RFS

Your reference: SSD-54836993
Our reference: DA20230220000698-Response to
Submissions-2

State Significant Development - Response to Submissions - Residential Subdivision/Masterplan

Stage 2 Huntlee NSW 2335, 12//DP1137569, 11//DP1137569, 3//DP813163, 4//DP813163, 13//DP1137569, 146//DP1233016

Surveyor: Andrew David McNamara
of DALY.SMITH Pty.Ltd.
Date of Survey:
Surveyors Ref: 20406 STG 2 DA

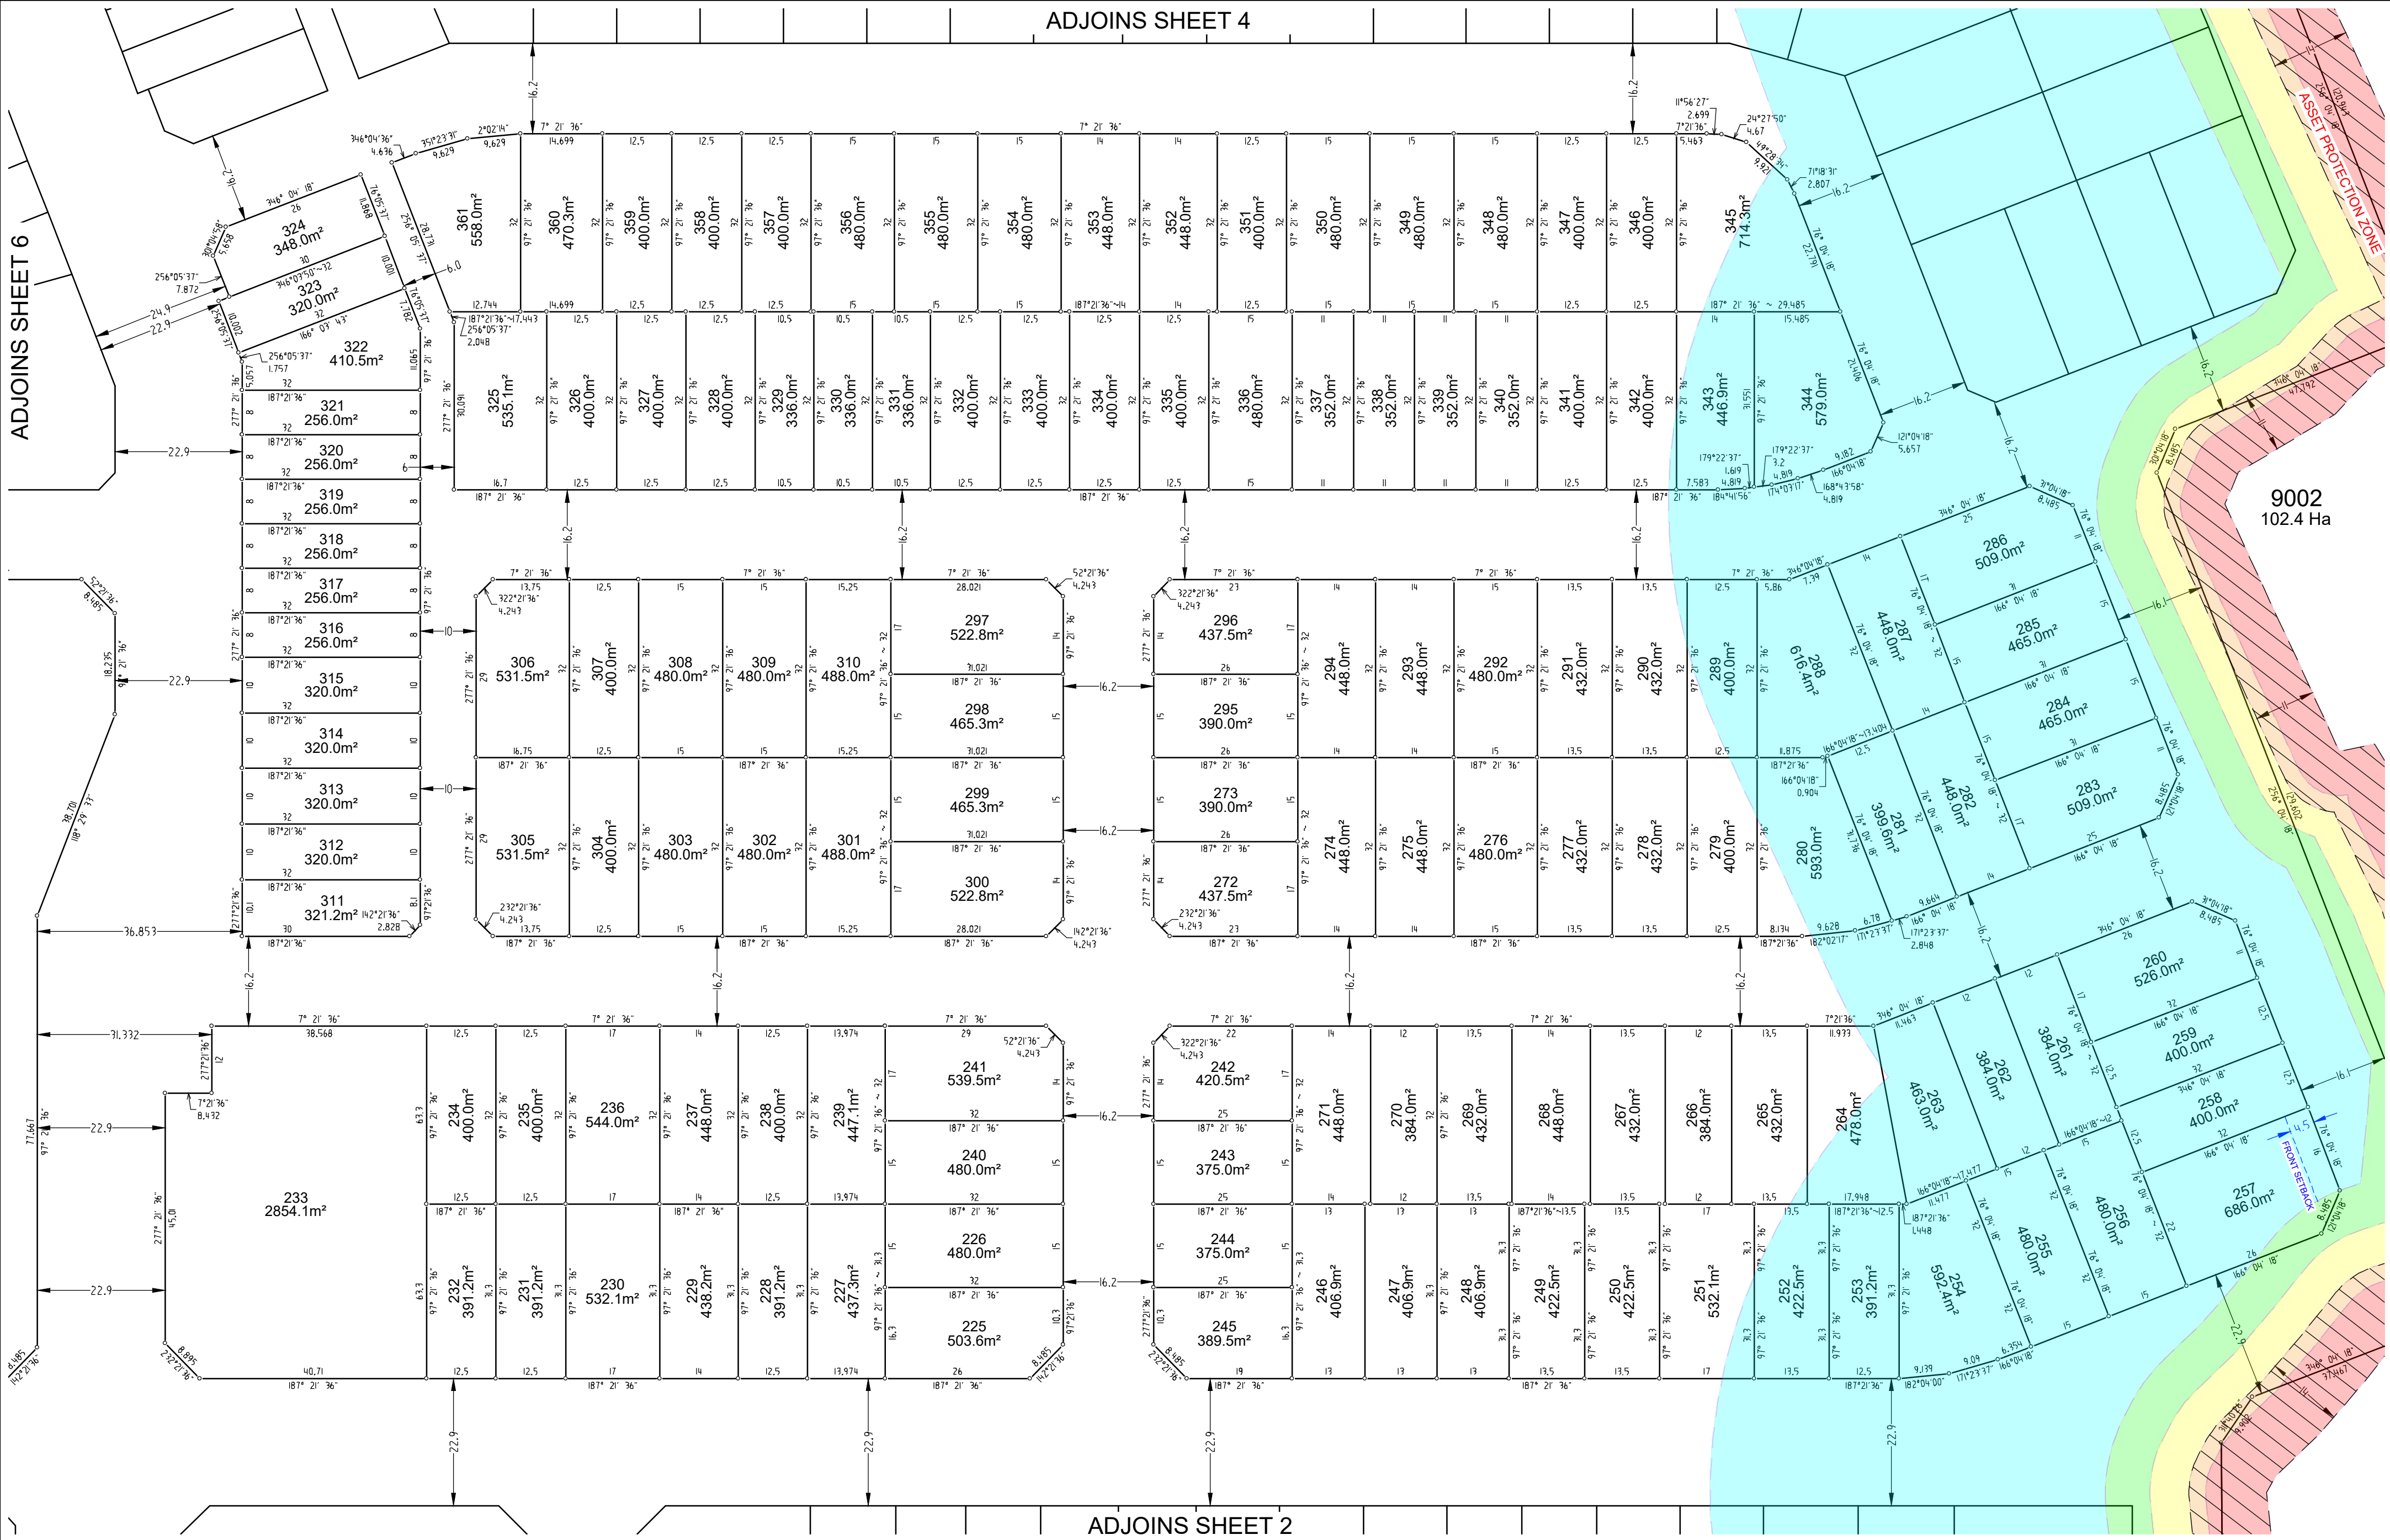
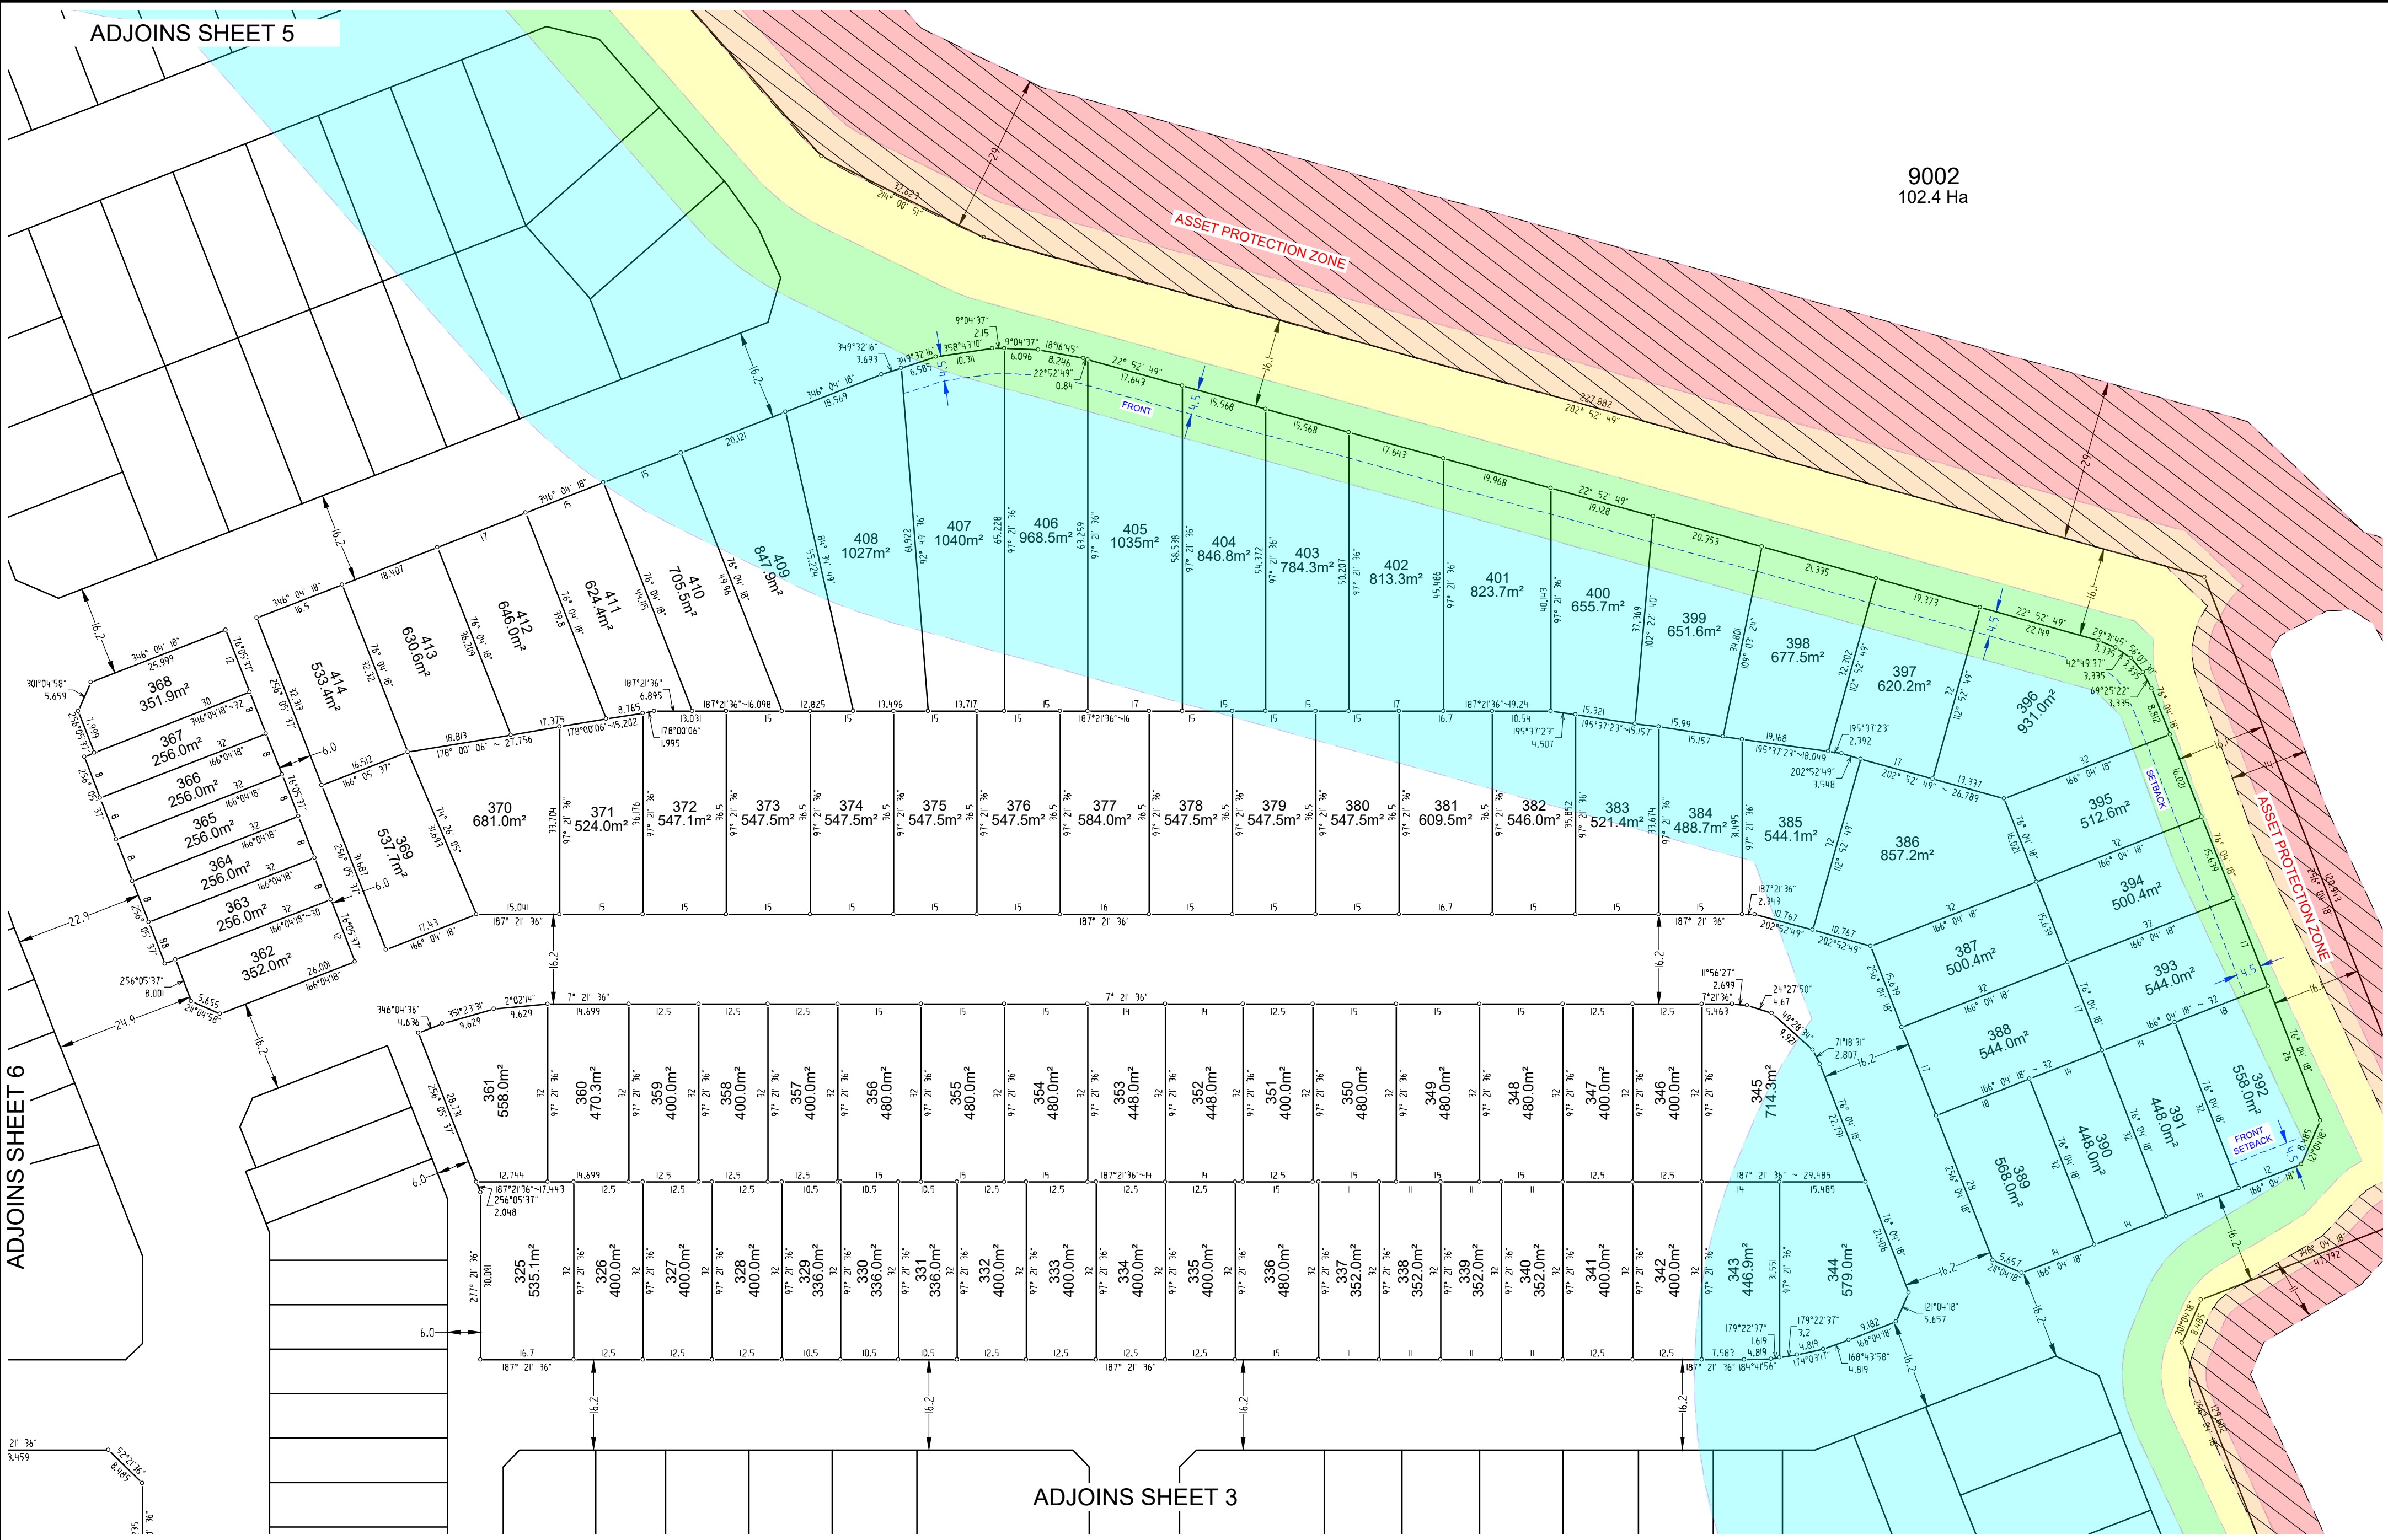
- With regard to Condition 3, the following matters need to be addressed for the bush fire attack level (BAL) Table and BAL-Plan provided in the bush fire report:

1. For clarity at the construction stage, the required setbacks are to be identified in metres on the BAL Plan as the distances for the BAL levels vary around the subdivision,

2. The BAL ratings applicable to each band of the BAL Plan are to be clearly identified on the plans,
 3. References to BAL-12 throughout the BAL Table must be amended to BAL-12.5,

- Review BAL Table for duplication of lot no. 799-806 (Sheets 6 & 7).
